Application No: Y/57/25/PL
Site Address: Sunnymead North End Road Yapton BN18 0DL
Description of works: Retention of fence at west of site on North End Road, hardstanding and access track and the creation of a residential caravan site with 3 No plots with associated parking, landscaping and facilities. This application is a Departure from the Development Plan and is in CIL Zone 3 (Zero Rated) as other development.

YPC has fully considered the above application and strongly object on the following grounds:

STREET SCENE - Viewed from North End Road [1:200]

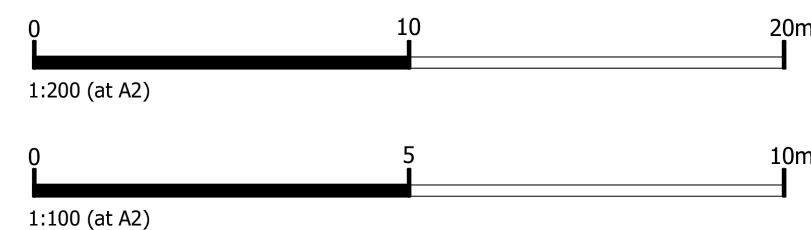
The proposed development appears incongruous and out of keeping with this important semi-rural location and for this reason should be refused or withdrawn until a more sympathetic approach to design can be applied.

YPC has reservations regarding the boundary treatment of the site. The urban form and scale of the fence is harmful to the character and appearance of the locality and is overtly dominant in the countryside and the street scene of North End Road. As such the fence causes detrimental harm to the character, appearance and visual amenity of the land. It should be reduced in height and soften with the introduction of a native deciduous hedgerow if progressed.
